G+L Responses Added 13-08-2025 – MILLER APPLICATION ONLY

Following a discussion between myself and Emma Mills, we appreciate the efforts made to progress the scheme. However, some matters remain unsatisfactorily addressed, but we are hopeful that a final further round of feedback and alterations should be able to resolve. These comments are:

Drawing to be read in conjunction with GLY0043 SP 01 Landscape Specification.

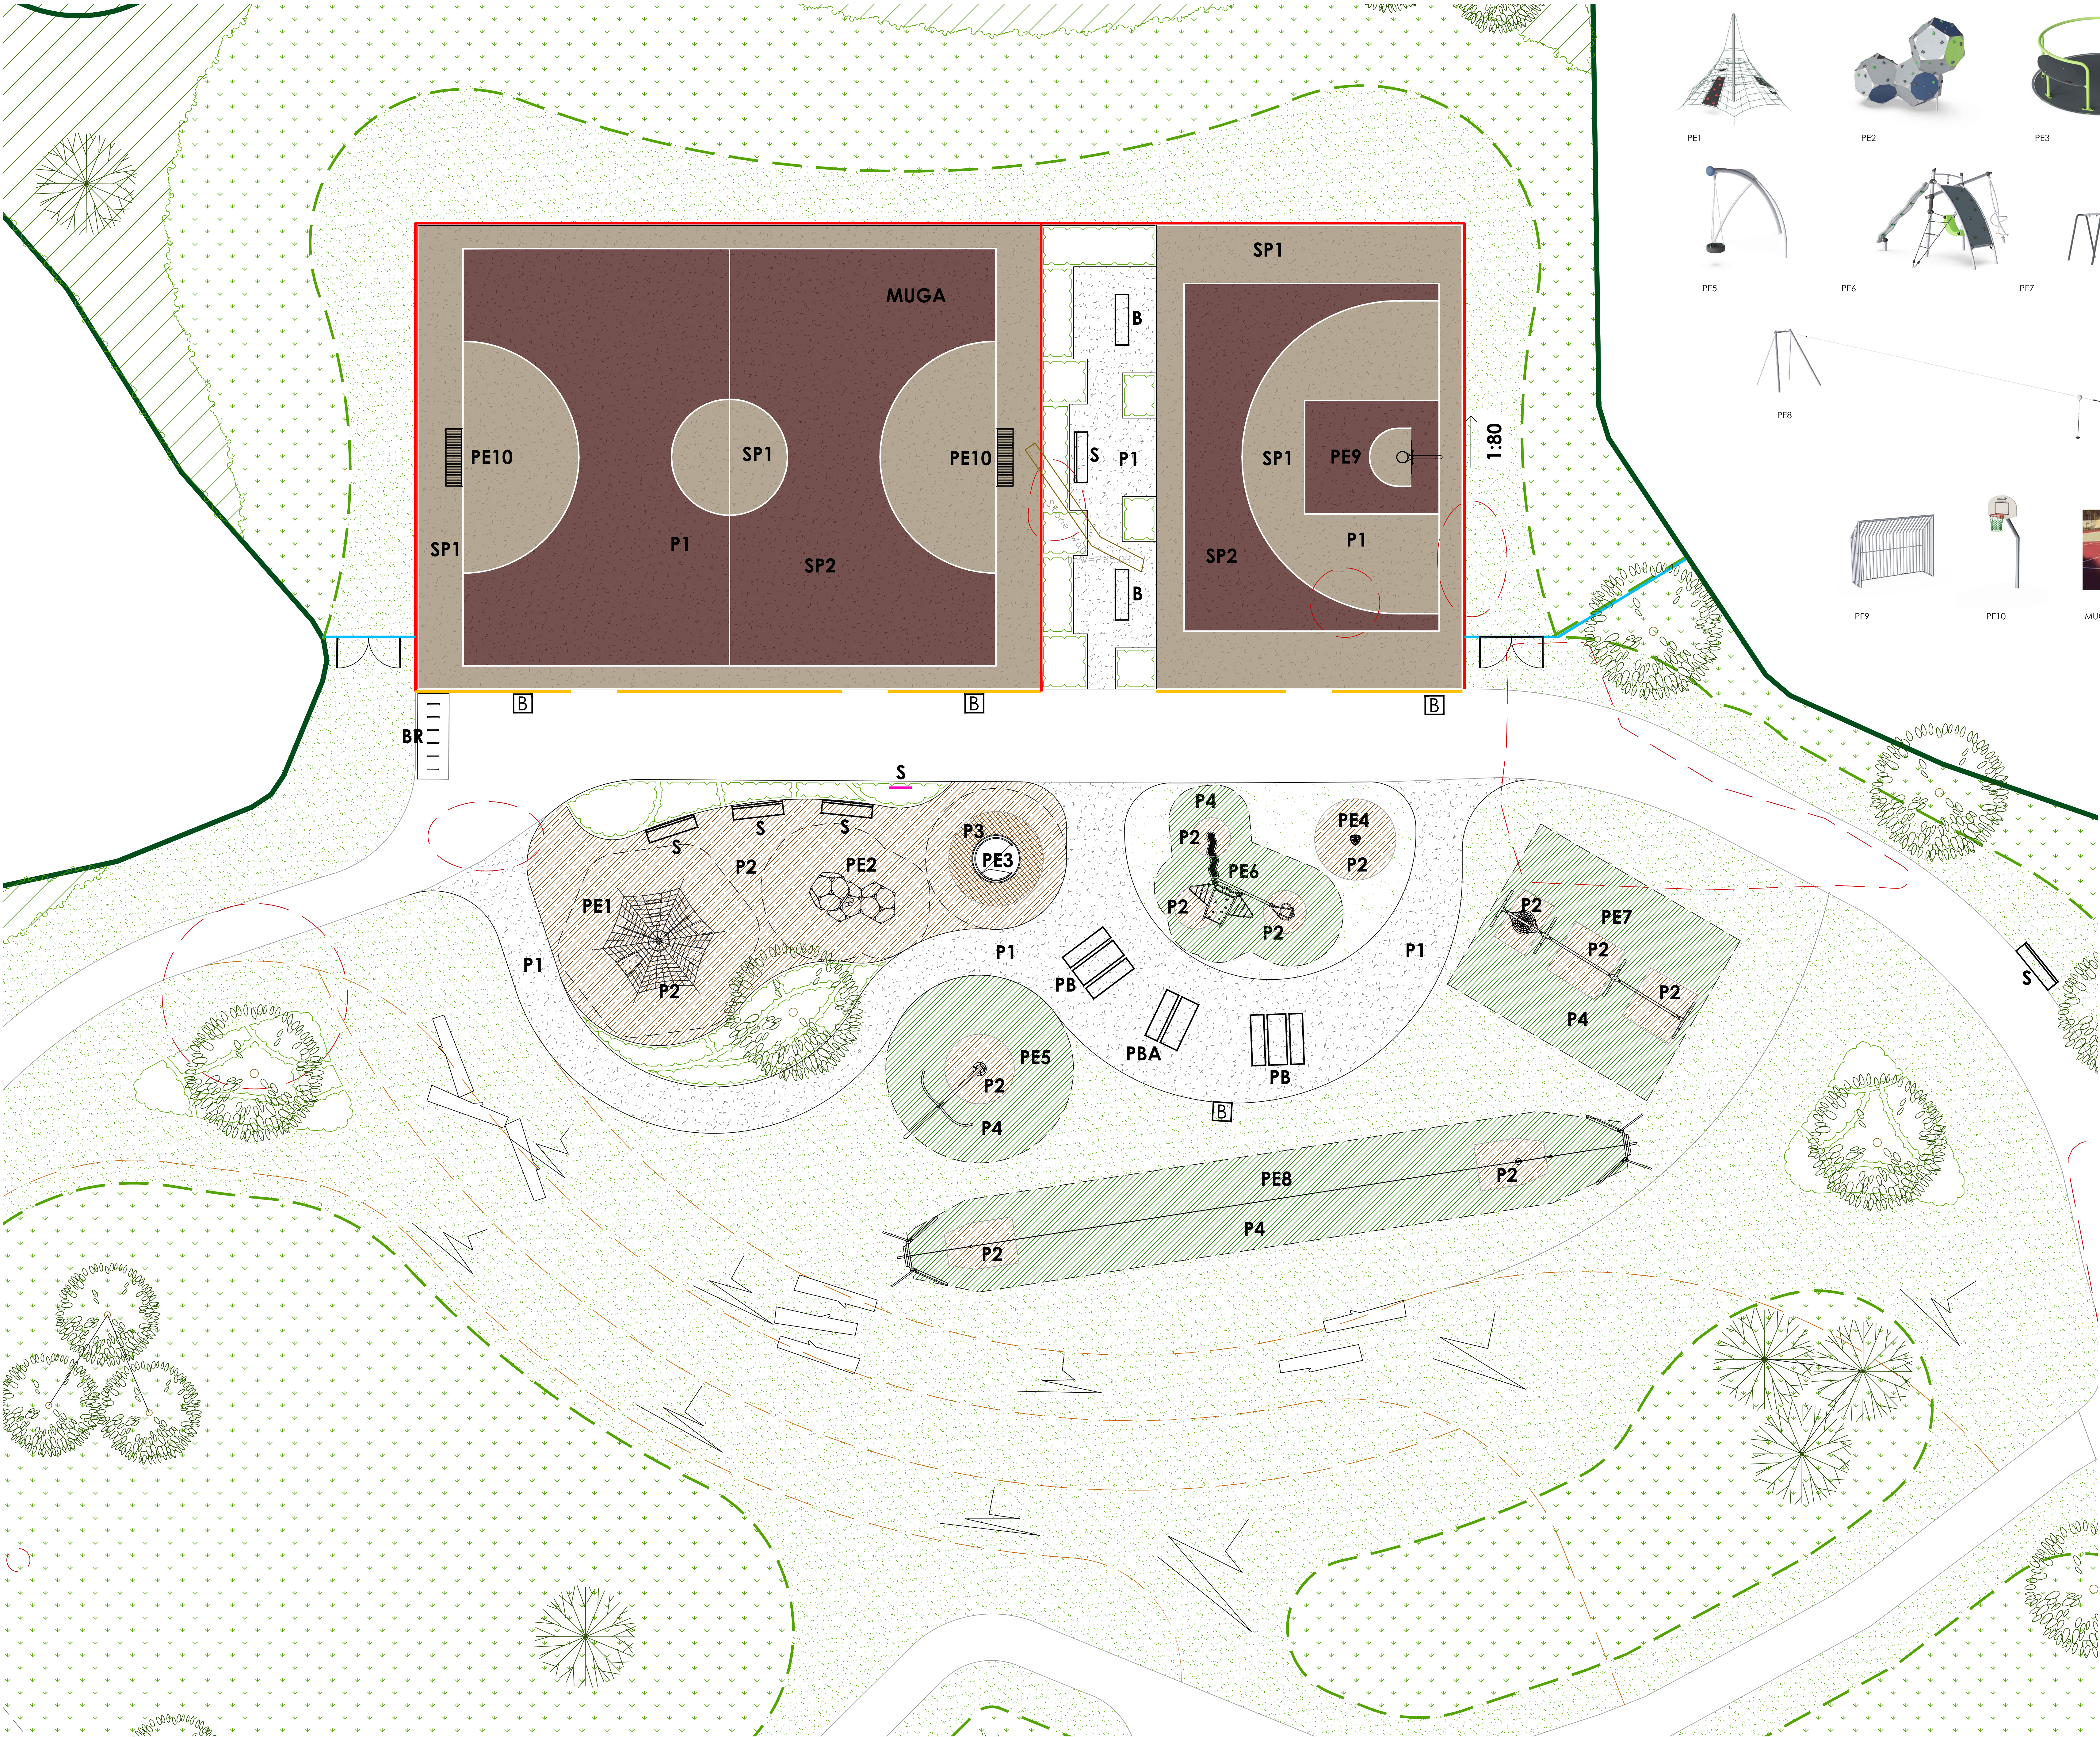
- Two entrances / exists were requested for the MUGA (anti-bully / entrapment). Replacing the single central entrance with an entrance at 1/3 and 2/3 down the length of the edge would be ideal.

- Bins have been proposed at most entrances into POS areas, which is welcomed. However, additional bins should be provided anywhere there is more than 1 bench or seat. I.e., in the middle of the NEAP are three benches: a bin next to them would be expected.

- Bike rack provided at LEAP, not NEAP. Why? Base expectation for bike rack and NEAP too.

- NEAP (Miller side): Better, but still issues / shortfall. See the following:
 - PE1, may be acceptable, depending on size. Do you have a product sheet that can be shared for that?

PE5 is incorrectly detailed on key. Not 100% clear on what it is supposed to be.

- PE4 and PE6 are too basic / small pieces of equipment. Larger and more complicated units, suitable for more mature children, are expected.

Updated as requested. See GLY0043 PP 01 B.

Additional bin added by the picnic benches. Bins respaced only MUGA boundary to improve accessibility/proximity to other seating areas.

Bike rack added to NEAP.

Product agreed with Emma Mills 13/08.

Dino Swing. Please see GLY0043 PP 01B.

Equipment substitutions agreed with Emma mills 13/08.
